Subject: FW: Planning Consultation on: Y/147/20/DOC (Burndell Road, Yapton)

We have the following comments regarding the application to discharge condition 5:

It is understood that an error in the original survey has resulted in the northern drainage catchment being constructed too deep and that a pumping station is now proposed to discharge water to the ditch. We do not support this proposal for the following reasons:

Drawing Title
**SURFACE WATER PUMPING STATION
OVERFLOW LONGSECTION**

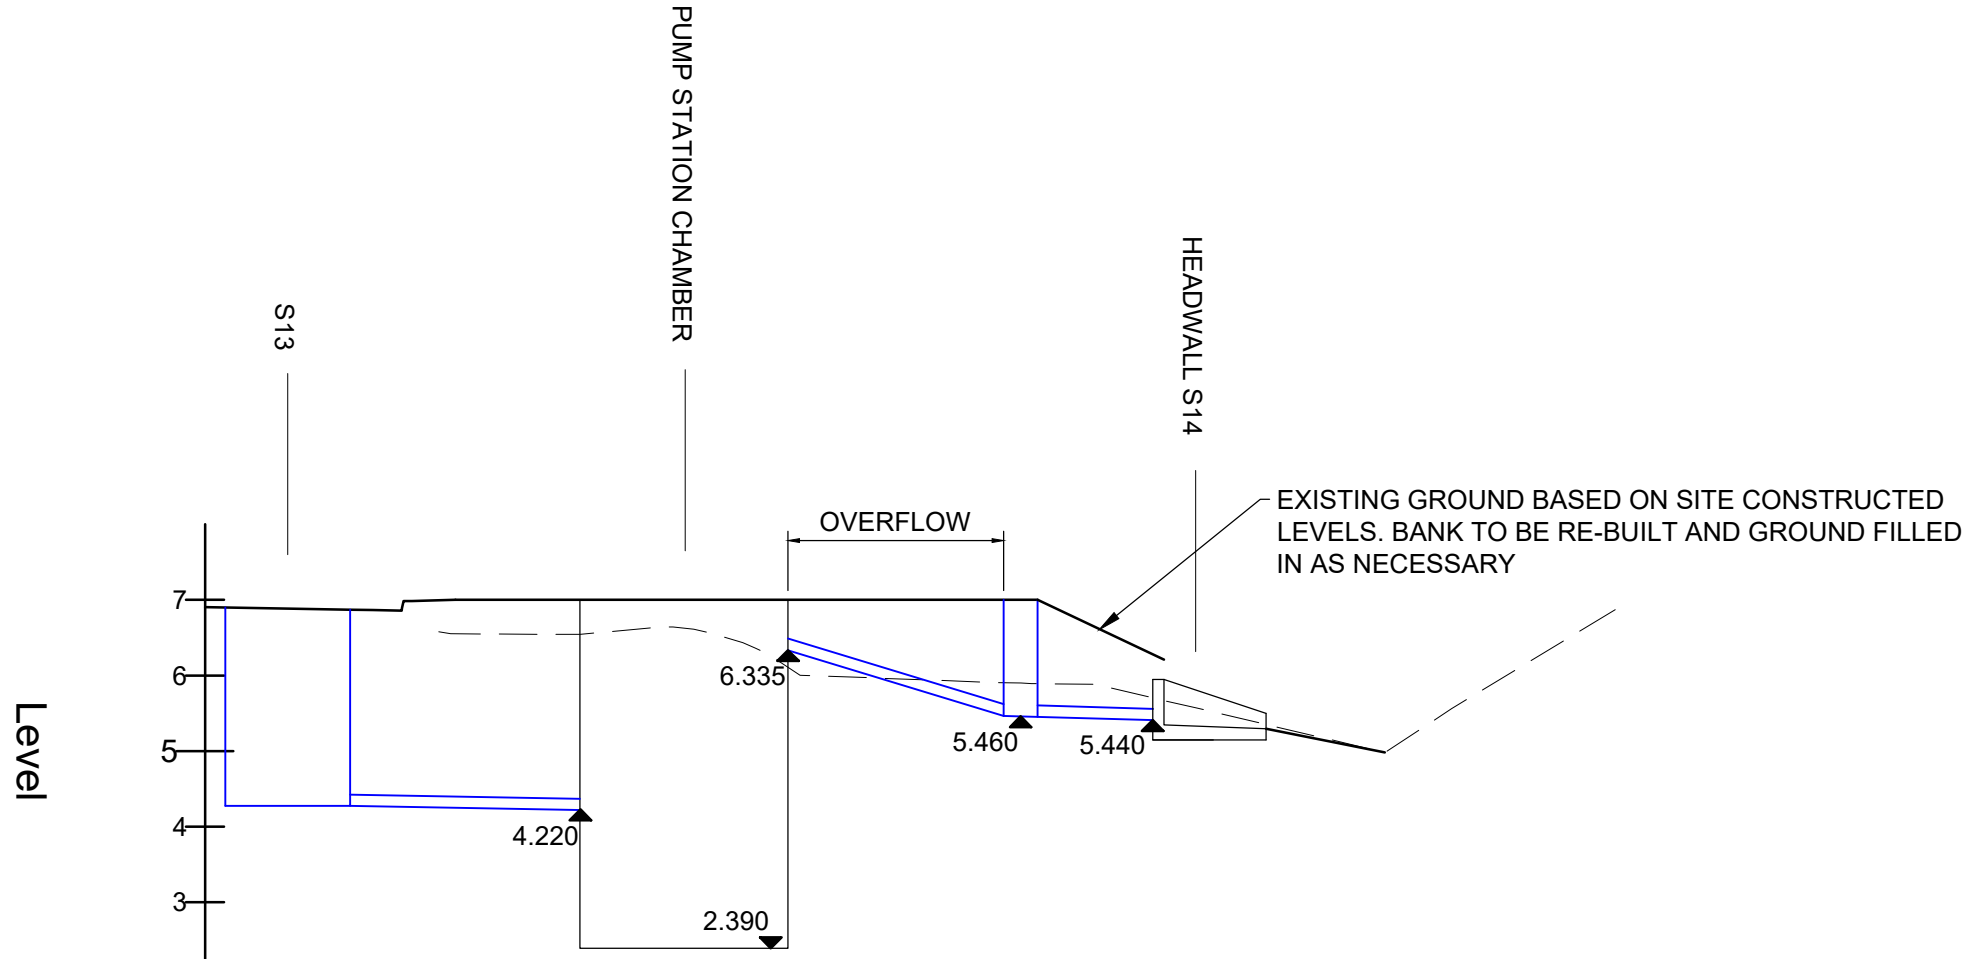
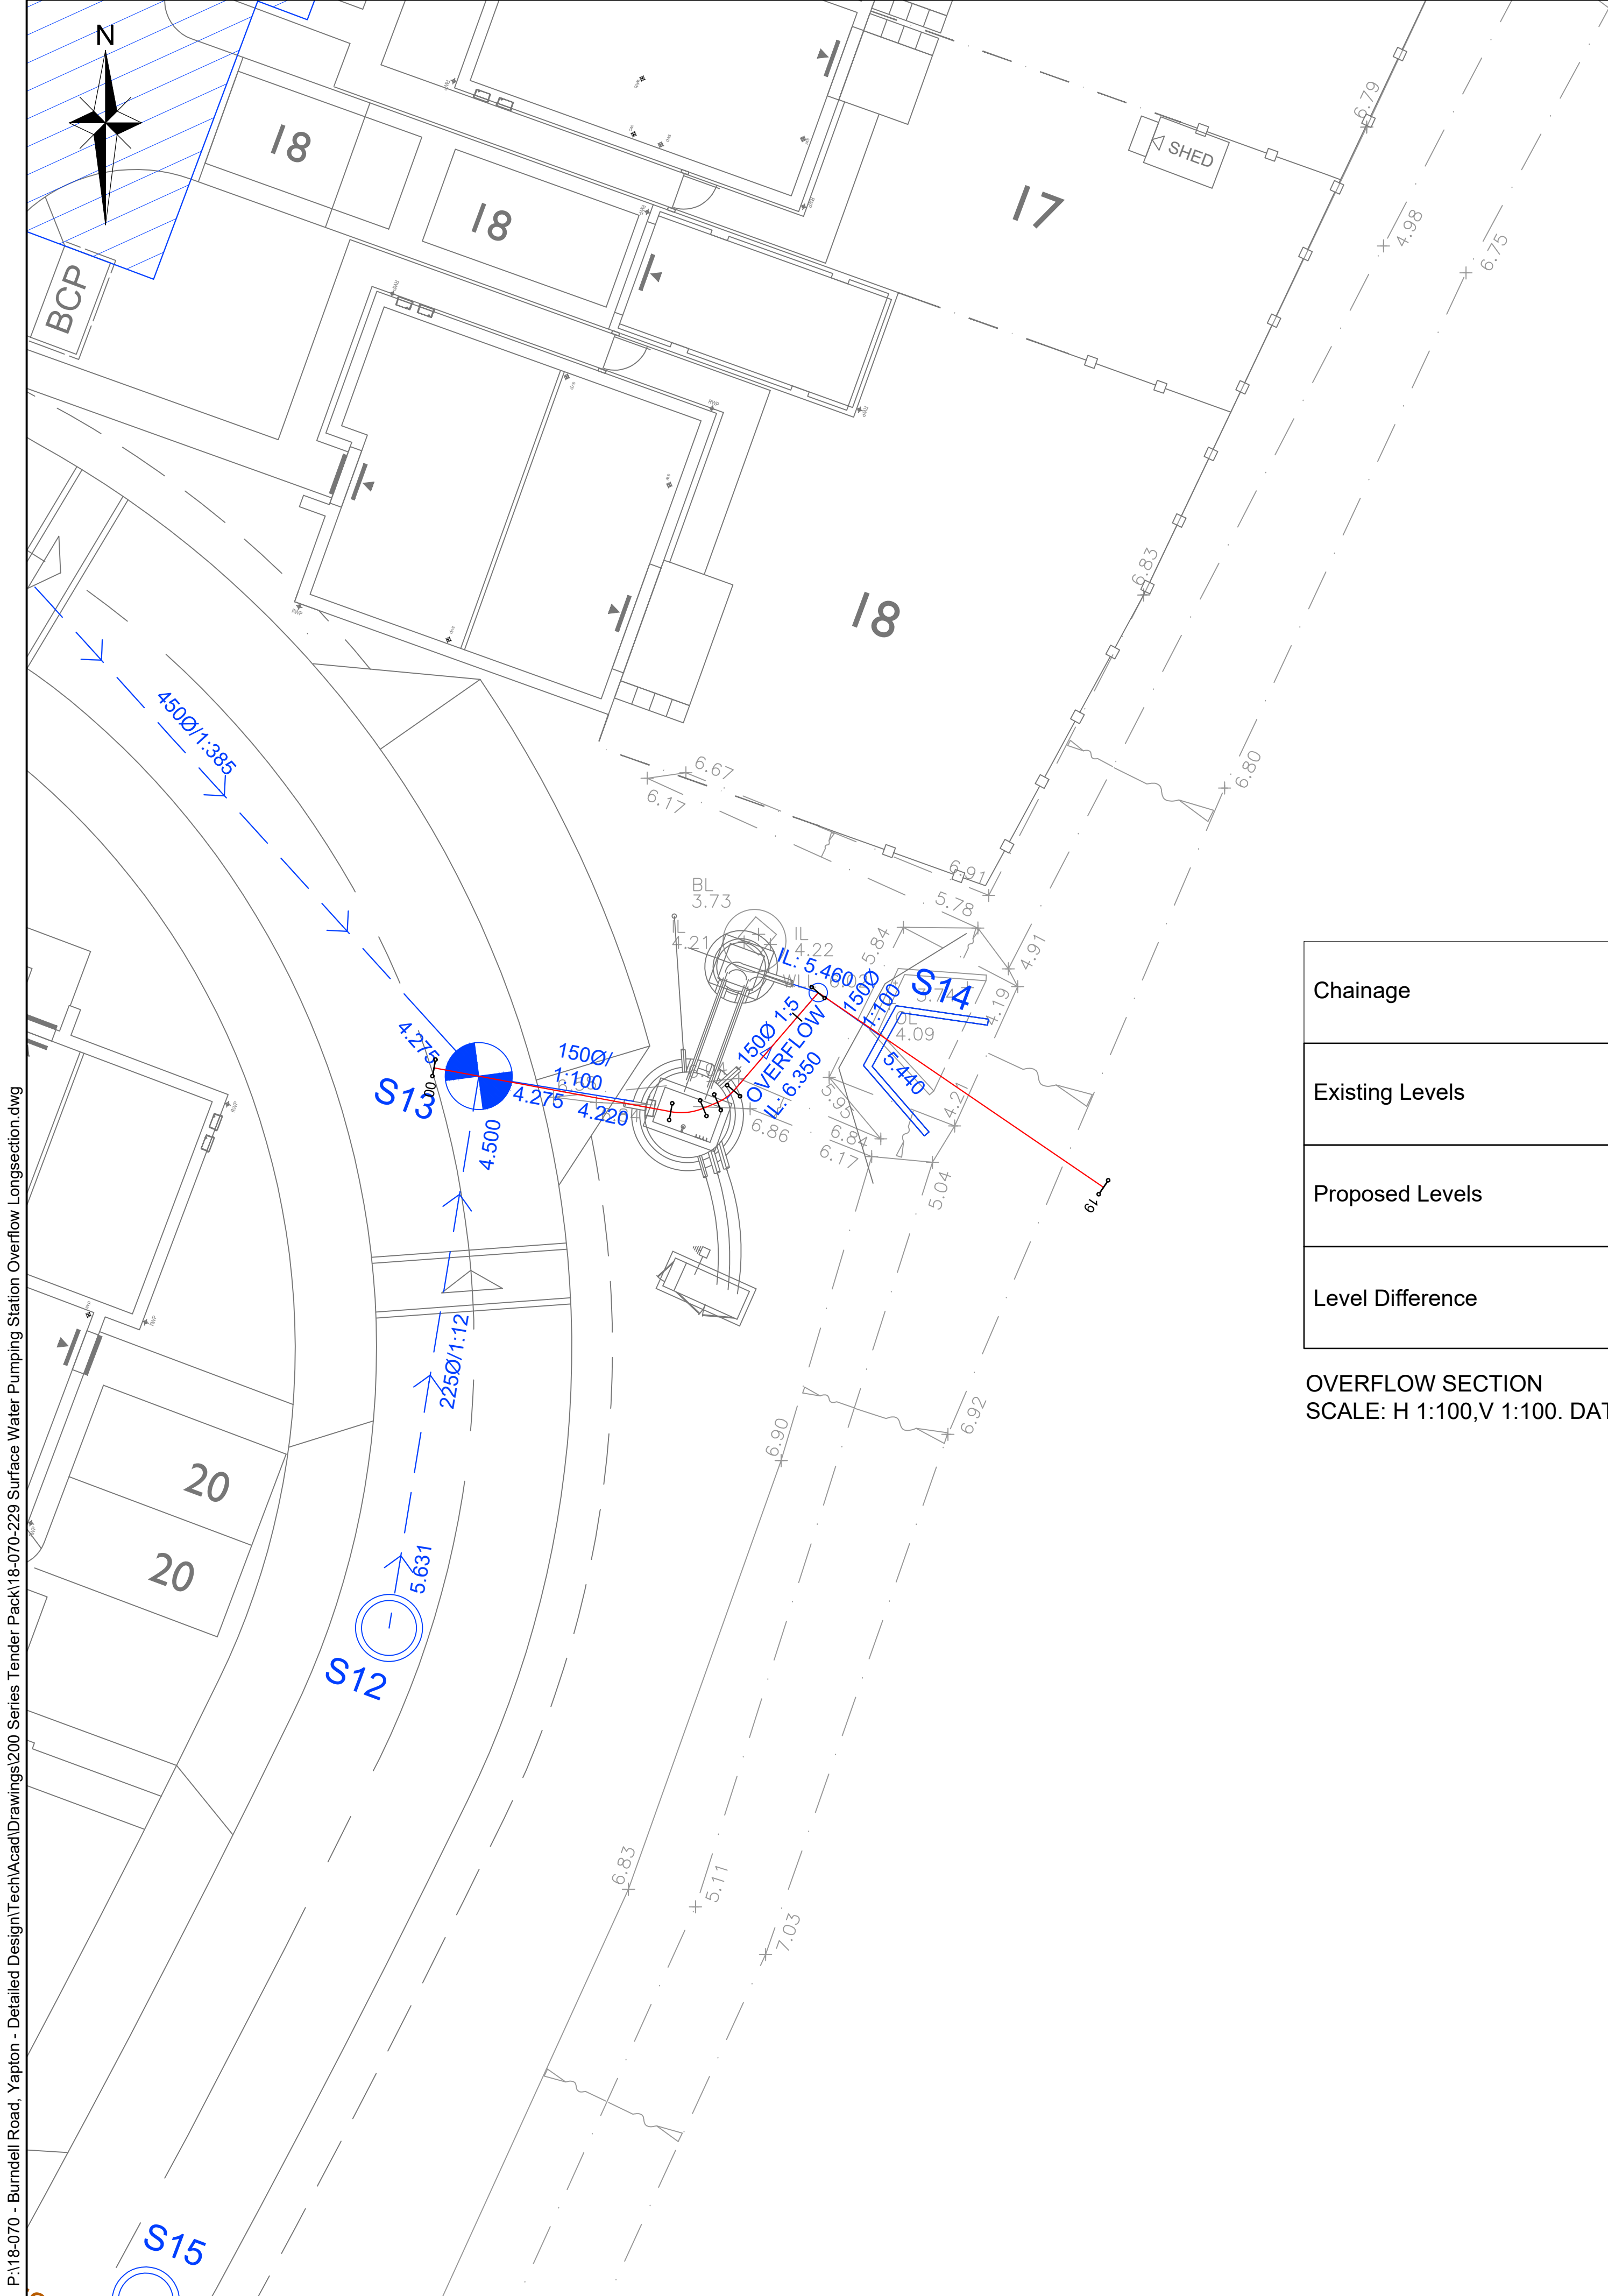
- a) It is standard practice for drainage to be constructed from the downstream up. If this had been completed the problem would not have occurred as the levels discrepancy would have been picked up from the start and adjustments made.
- b) Pumping stations are prone to failure and we are aware of sites in the county where pumping stations have resulted in on and offsite flood risk being increased.
- c) Pumping stations are not sustainable.
- d) Pumping stations require significant maintenance, this will place an unreasonable financial burden upon residents.
- e) Insufficient justification has been provided to demonstrate that a gravity solution cannot be achieved. If it is required to reconstruct some of the drainage network then this should occur.
